RE: SSD-11802230 SYDNEY OLYMPIC PARK NEW HIGH SCHOOL SSDA RESPONSE TO SUBMISSIONS ON TRAFFIC

This letter accompanies an Amendment Report for the project and forms an update to the previously issued Response to Submissions on Traffic letter. This letter reflects the proposed amendments and DPE's request for additional information. The proposed amendments generally include placing a 850 cap on student numbers and removing all school development from the previously approved Ridge Road reserve.

Table 1 Response to submissions on traffic and Transport

Sheet title
SSDA
Site Plan Proposed

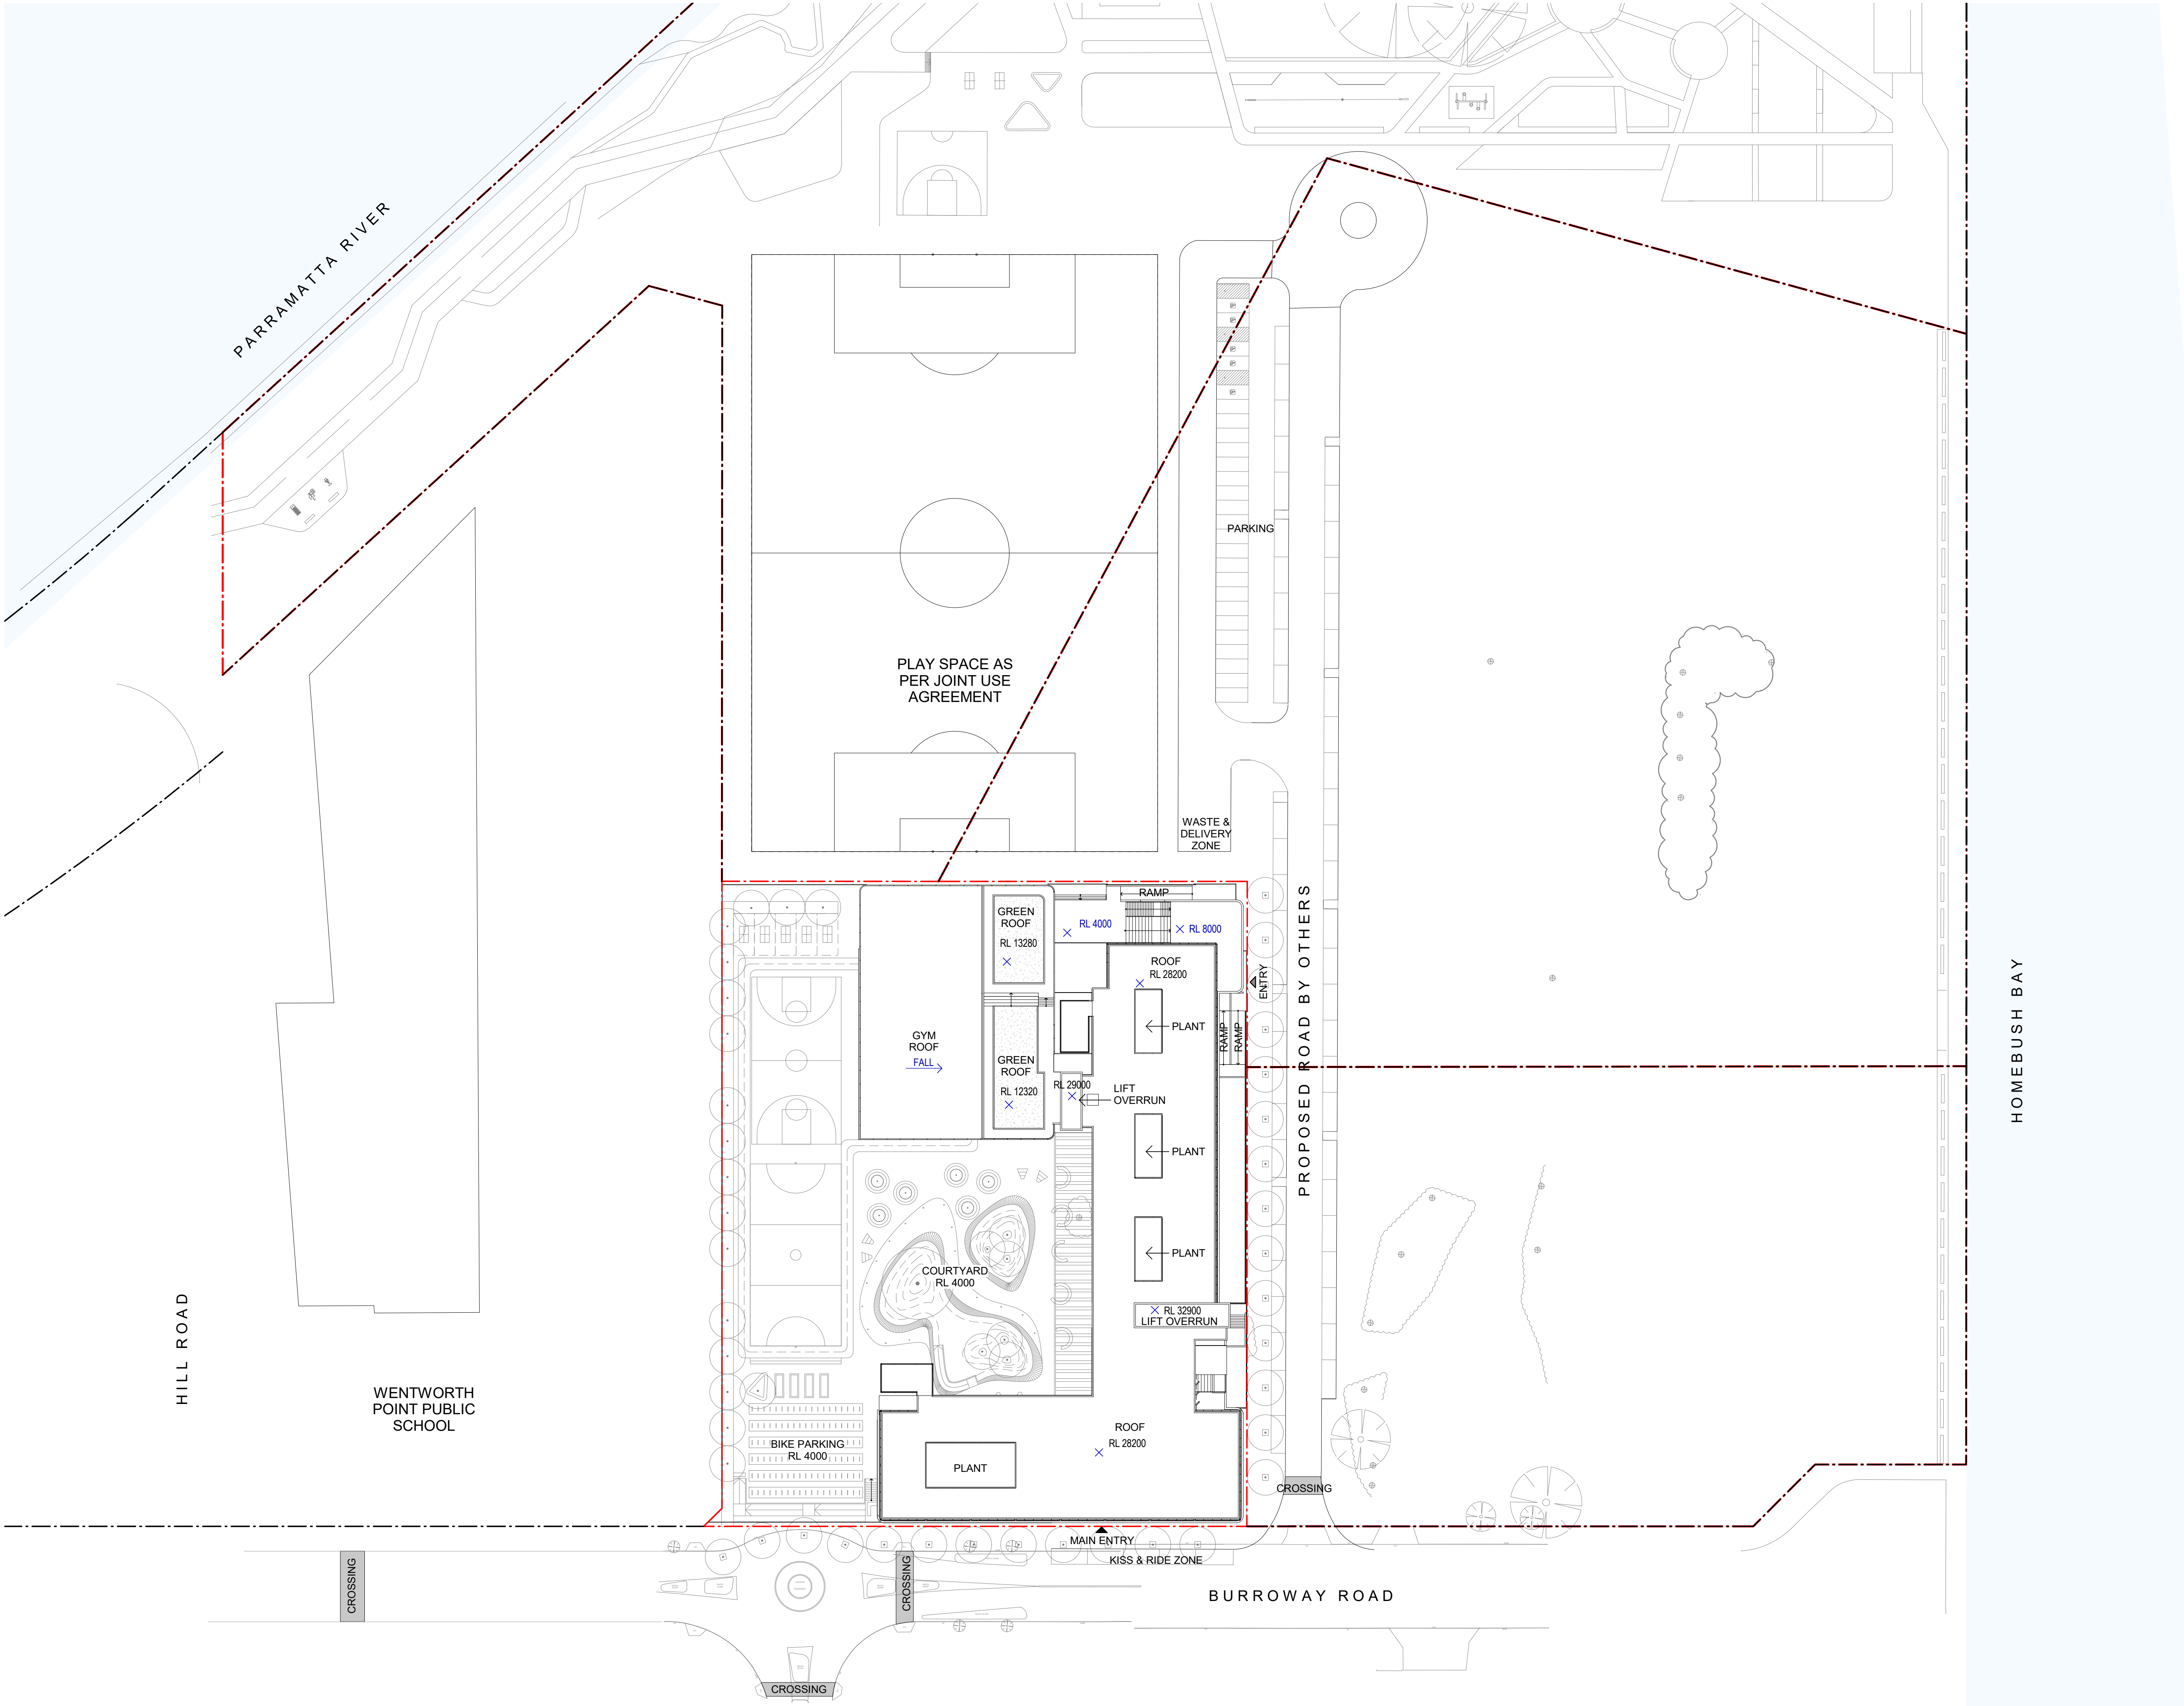
A 2.3	Demonstrate that the footpath width on Burroway Road adjacent to the roundabout and on site bicycle parking is sufficient to cater for the expected pedestrian demand and complies with relevant standards.	<p>School designs have been modified to be consistent with Development Consent DA 40-2015 as modified, in particular the approved Ridge Road. As a result of this, there are changes proposed to the concept layout, including a reconfiguration of the site.</p> <p>With the new design, the pinch point is eradicated because the site is now integrated with the Ridge Road design. Refer to below for an extract of the design and the interface with the footpath.</p>	Addendum

SDRP 03 Advice Letter from Government Architect New South Wales dated 20 October 2021			
E 10	10. Footpath width – The footpath at the roundabout on Burroway Road is too narrow and poses a safety risk. Confirm resolution of this area to enable shared access for cyclists and pedestrians during peak periods.	<p>School designs have been modified to be consistent with Development Consent DA 40-2015 as modified, in particular the approved Ridge Road. As a result of this, there are changes proposed to the concept layout, including a reconfiguration of the site.</p> <p>With the new design, the pinch point is eradicated because the site is now integrated with the Ridge Road design. Refer to below for an extract of the design and the interface with the footpath.</p>	Addendum
